Consultation Response: Kirklees Council Conservation & Design (Biodiversity)

<i>Is this a response to an informal consultation request?</i> Yes ☐ No ☒	
Date	19/04/2017
Officer responding	Tom Stephenson
Application number	2017/90769
Purpose	Initial consultation response
Location	Adj, Fieldhead, Hill Lane, Holmfirth, HD9 3BW

Front/South Elevation As Proposed
Scale 1:100
0m 1m 2m 3m 4m 5m

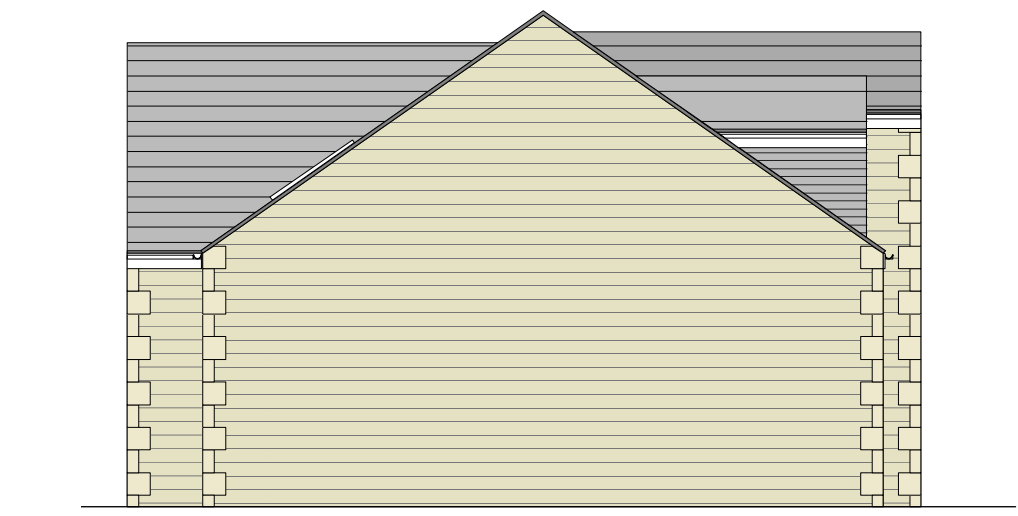
1. The new dwelling will include a bat roost box (Ecosurv bat brick, or similar) installed integral to the southern elevation at a height of at least 3 meters and not directly above doors or windows. Hereafter the boxes shall be retained. Photographic evidence showing the correct installation shall be submitted to the local planning authority.
